Sent: 30 November 2009 13:50
To: Planning
Subject: Comments Added: VINE COTTAGE, WELL ROAD, NORTHAW

Application ID: S6/2009/2273/FP - Mr P Jefcoate Application Owner: Welwyn & Hatfield Borough Council (Development Control Officer)

Location: VINE COTTAGE, WELL ROAD, NORTHAW Deadline Date: 30/11/2009 13:24:34

Description: ERECTION OF 2 STOREY SIDE EXTENSION, REAR EXTENSION AND NEW FRONT DORMER AND REPLACEMENT FRONT PORCH AND NEW OUTBUILDING FOLLOWING DEMOLITION OF EXISTING OUTBUILDING

PROPOSED ELEVATIONS - 1:100

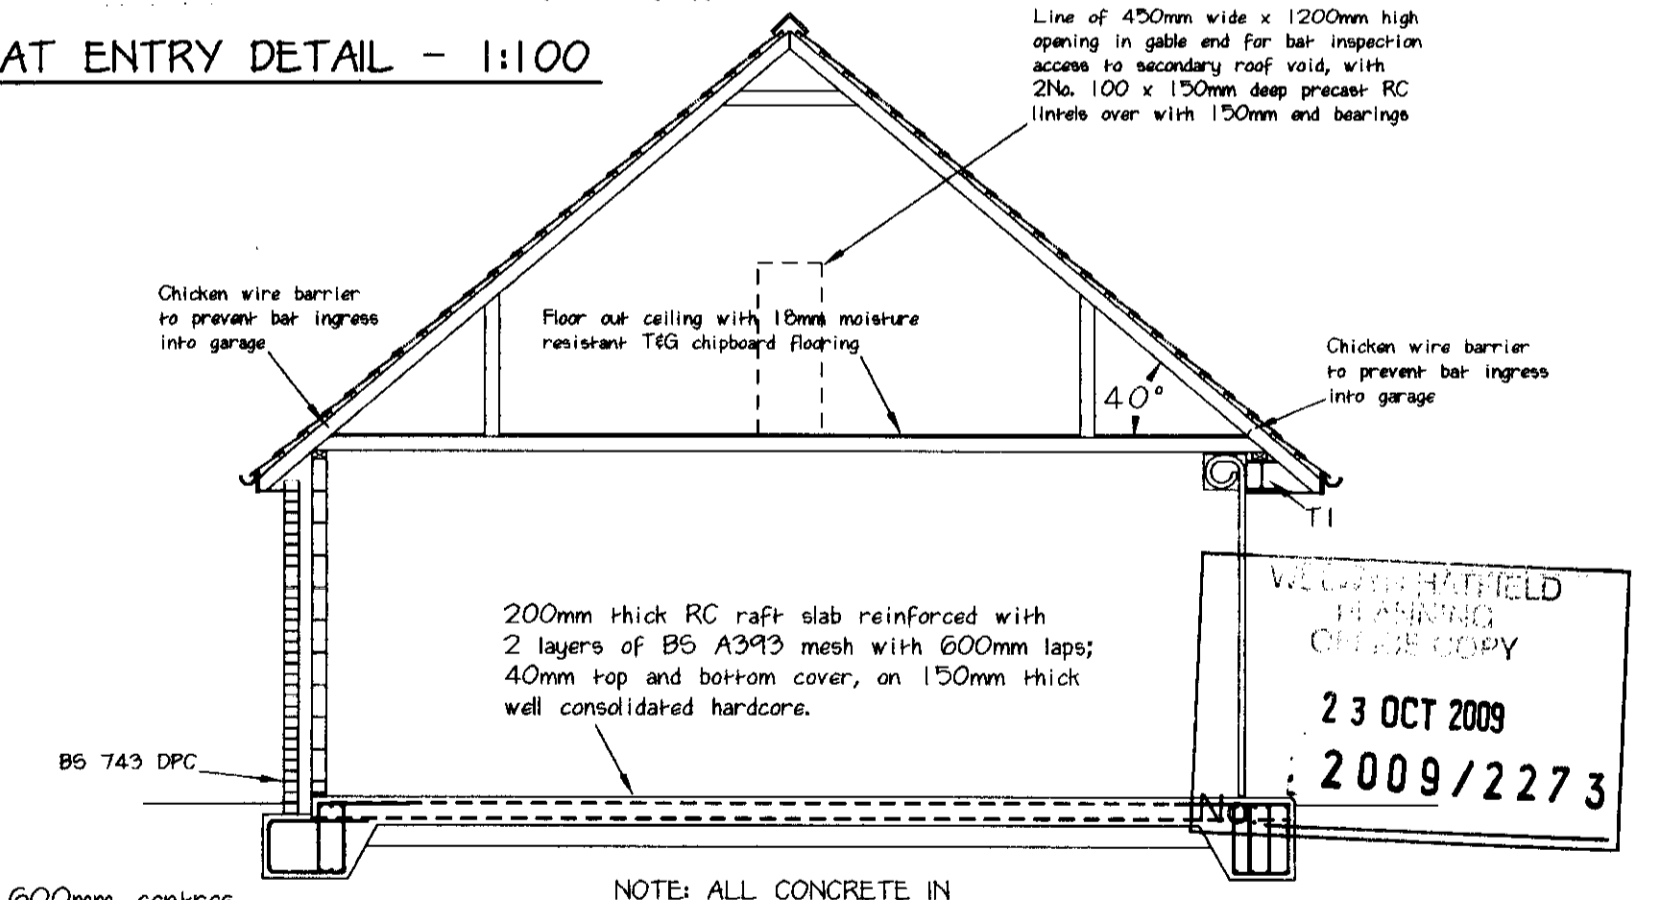
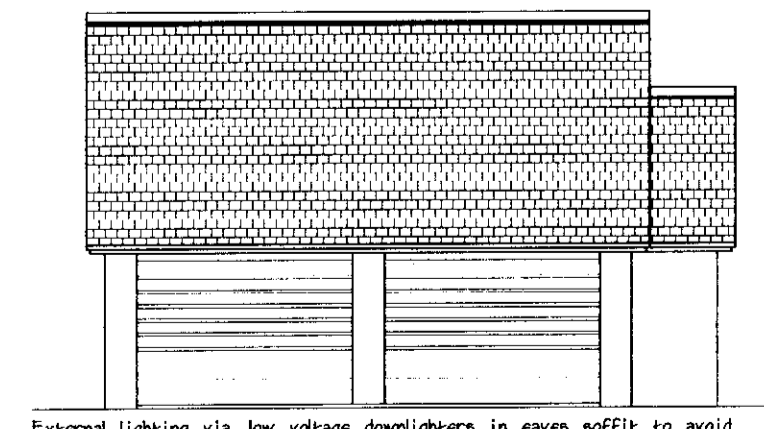
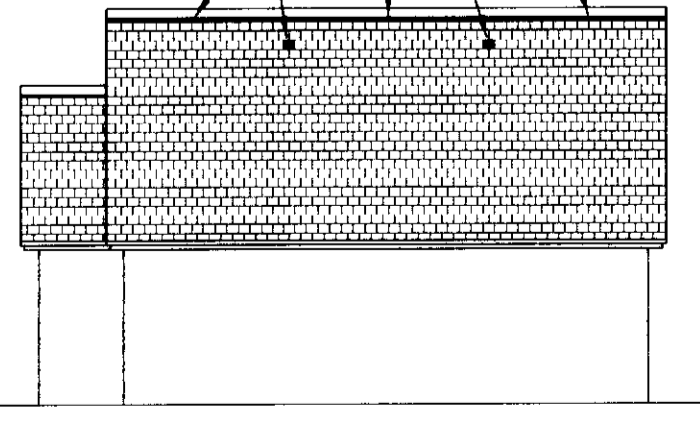
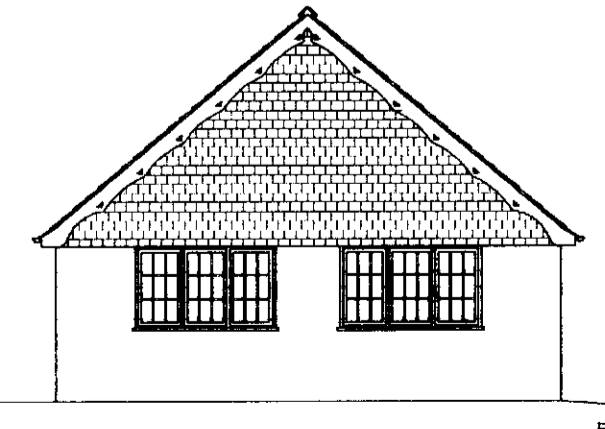
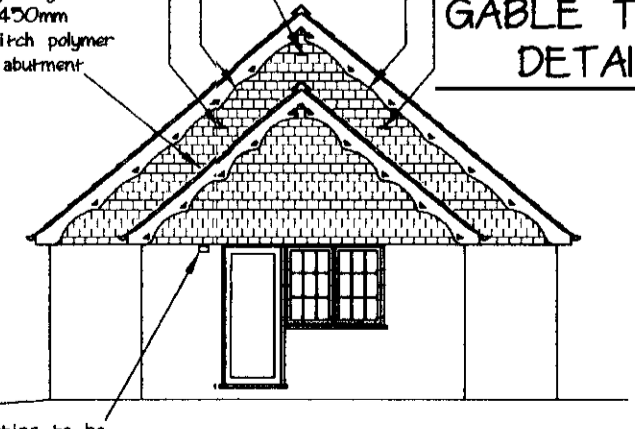
Comment: This is a Green Belt location and the extensions appear to be disproportionate. If allowed it would make the dwelling materially larger than the existing contrary to the advice given in Para.3.6 PPG 2 of the WHDPLAN 2005
